CITY OF ALBUQUERQUE

Re: Gonzalez Residence
2100 Edna Ave NW
Traffic Circulation Layout
Engineer's Stamp 08-23-16 (J13D203)

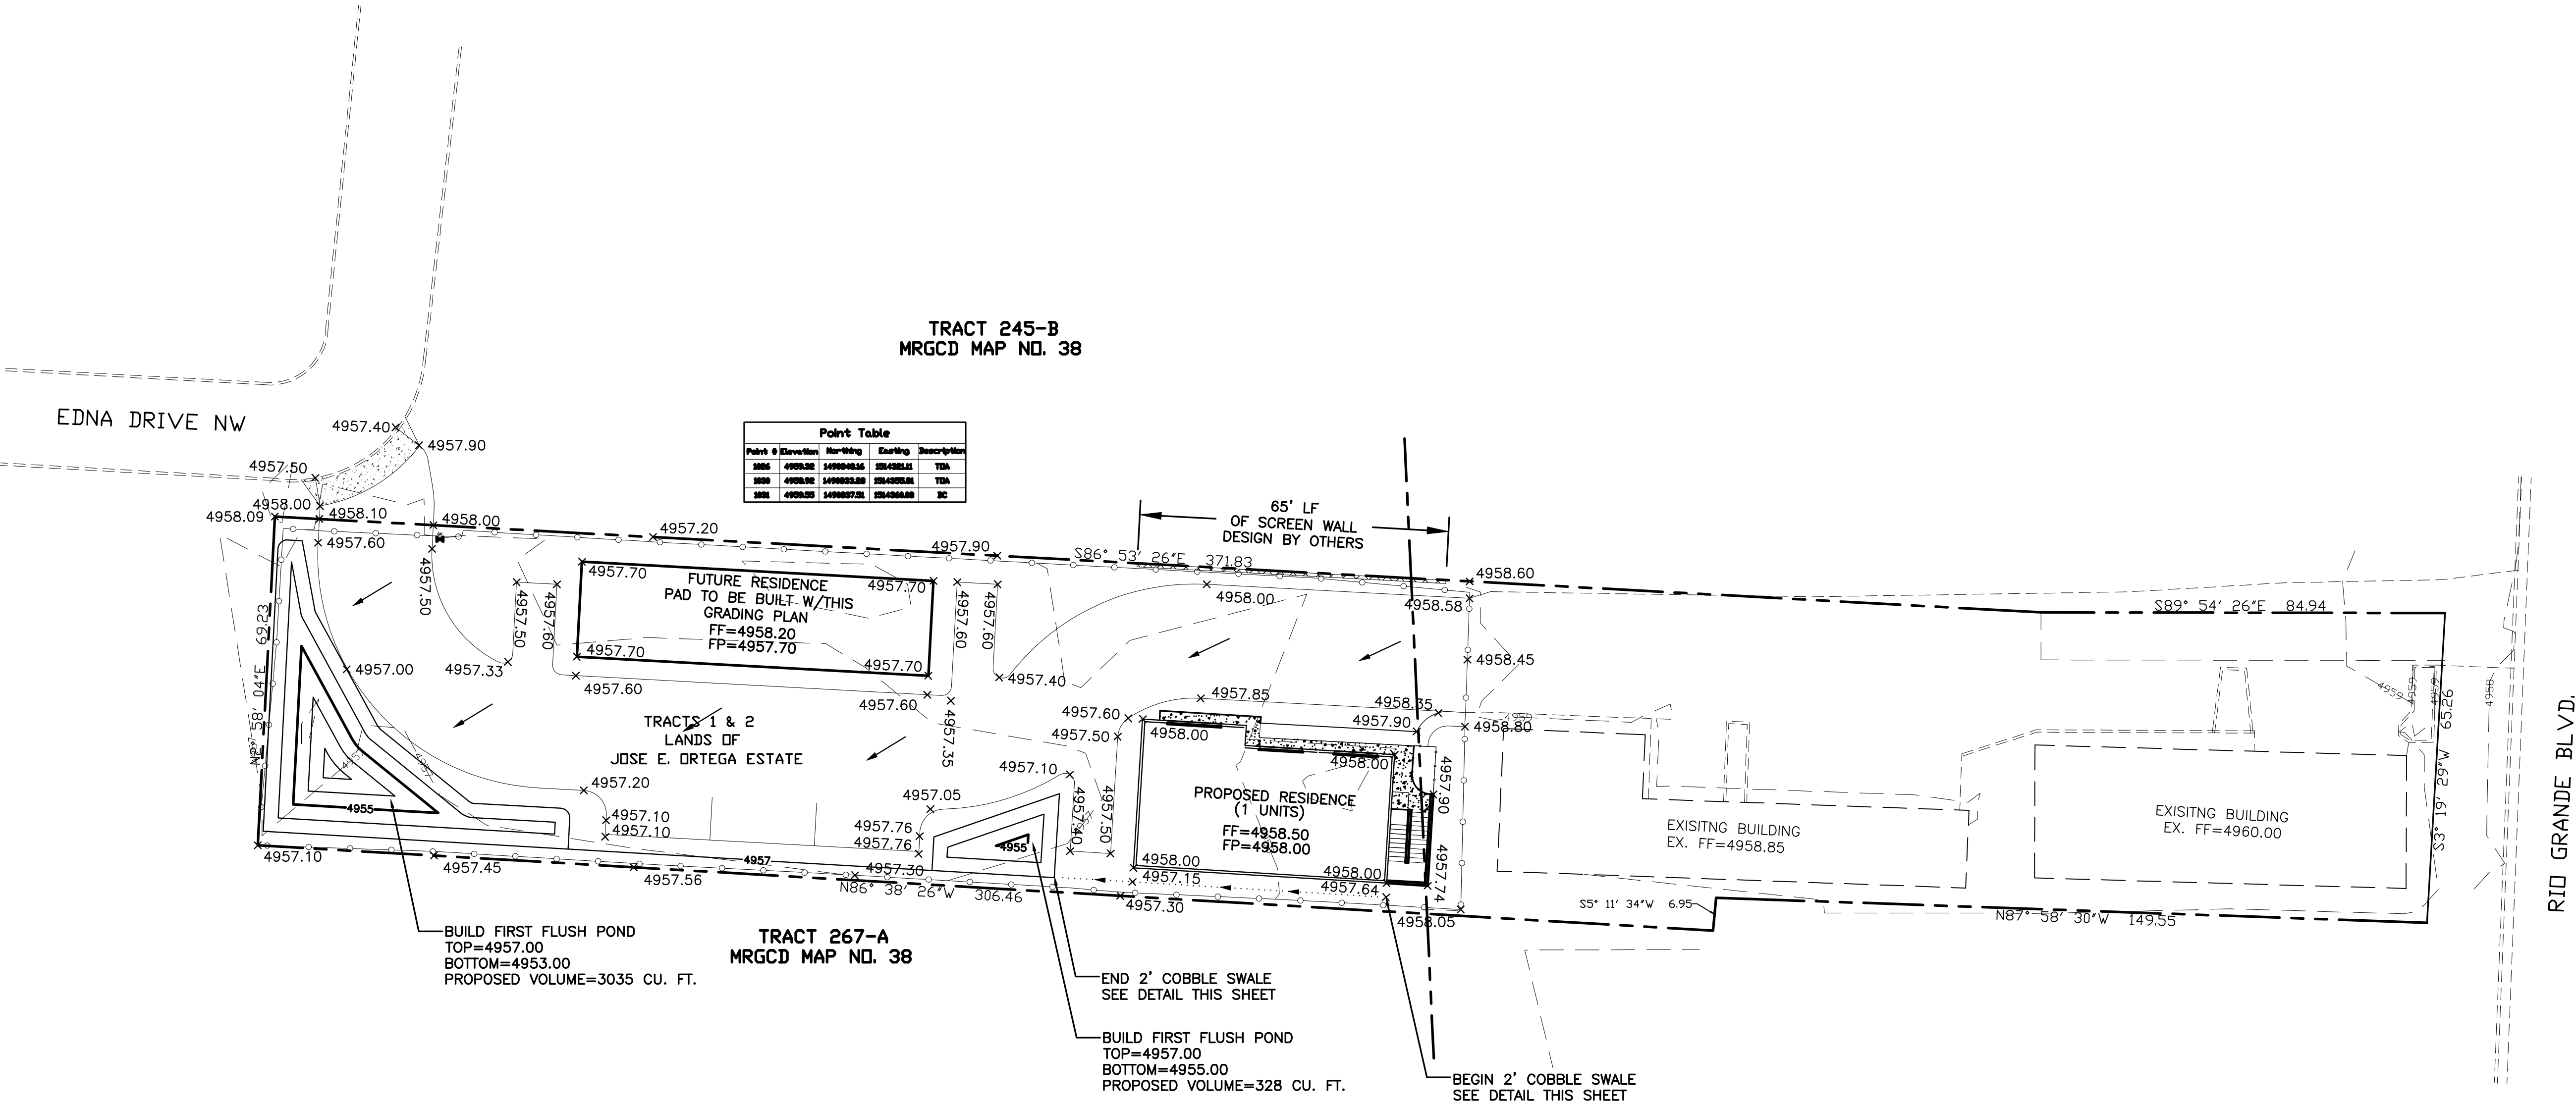
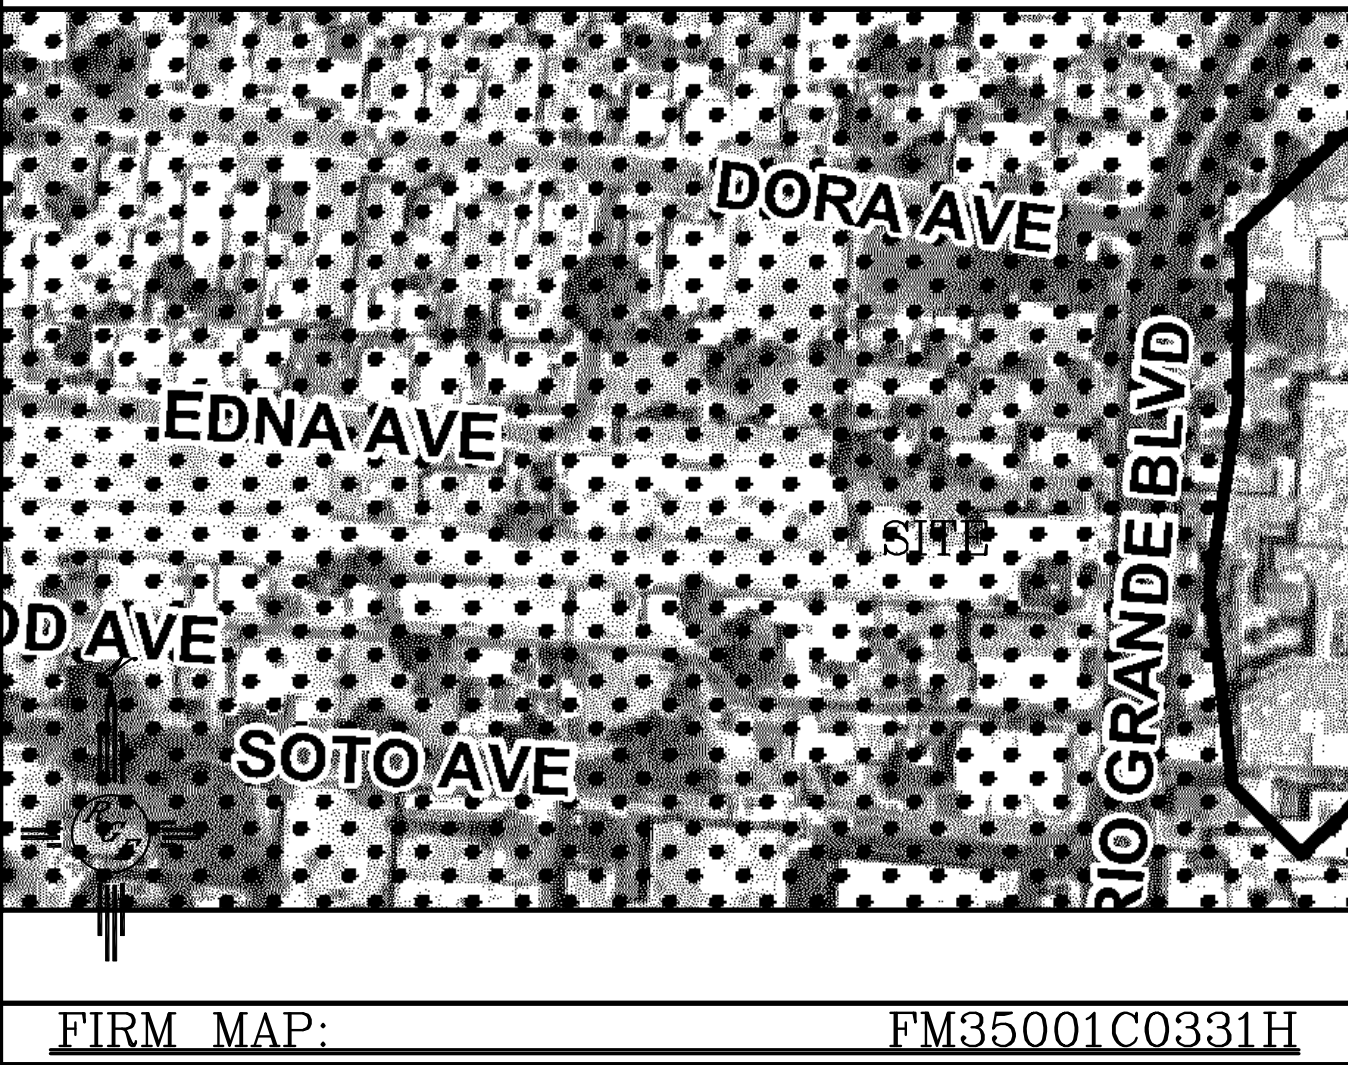
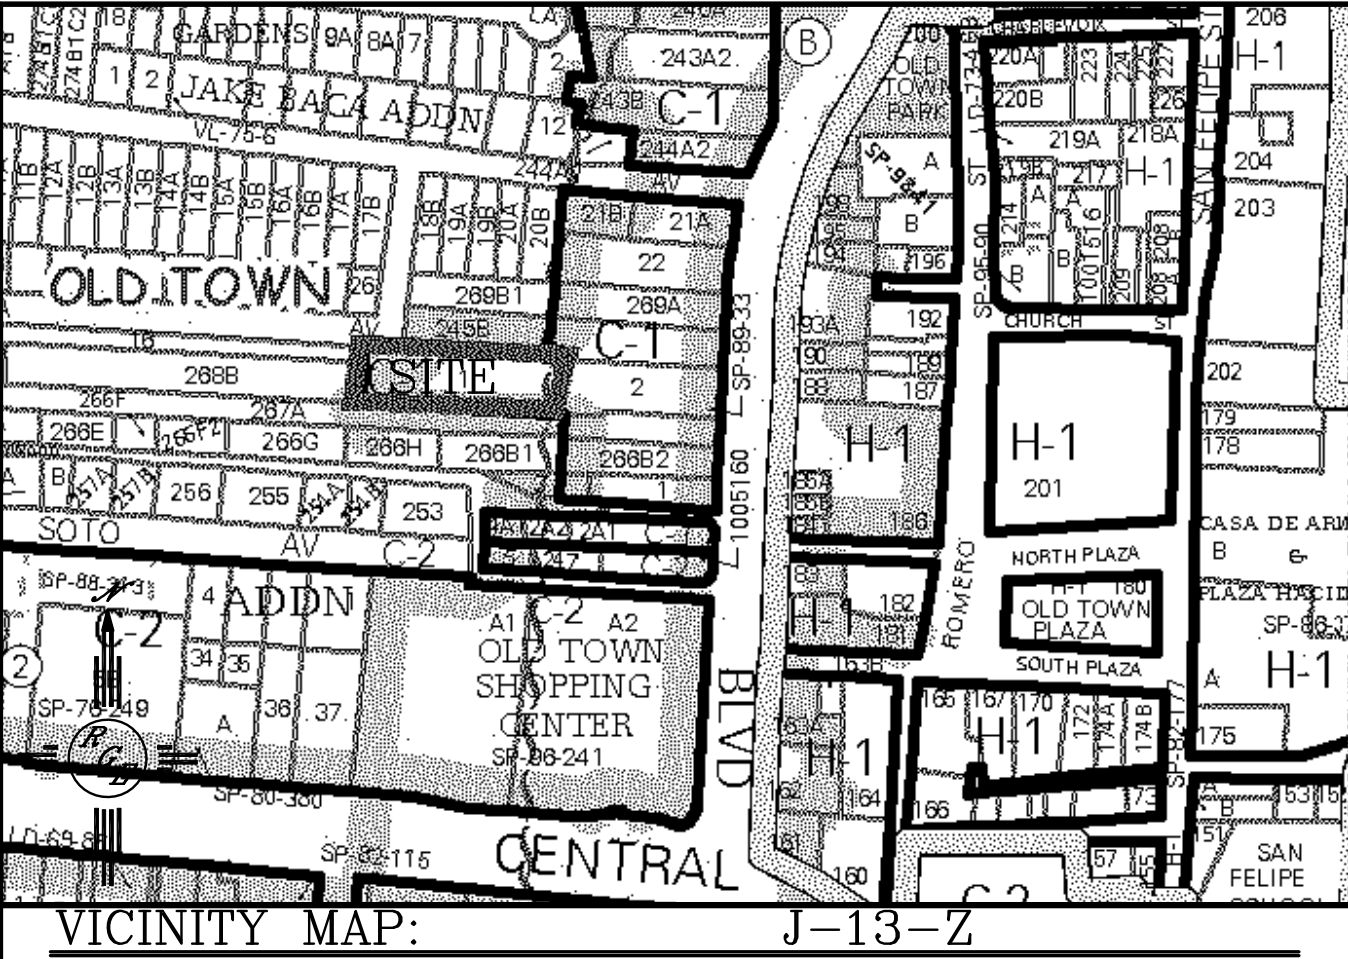
1. Please review and revise plan to provide all information listed on the attached Traffic Circulation Layout checklist.
2. Please refer to the attached Accessible Parking Checklist and revise the plan accordingly.
3. If the existing approved TCL dated 05-28-2014 is being revised please indicate how.
4. Access to this site from Edna Ave is denied.
5. Please include two copies of the traffic circulation layout at the next submittal.
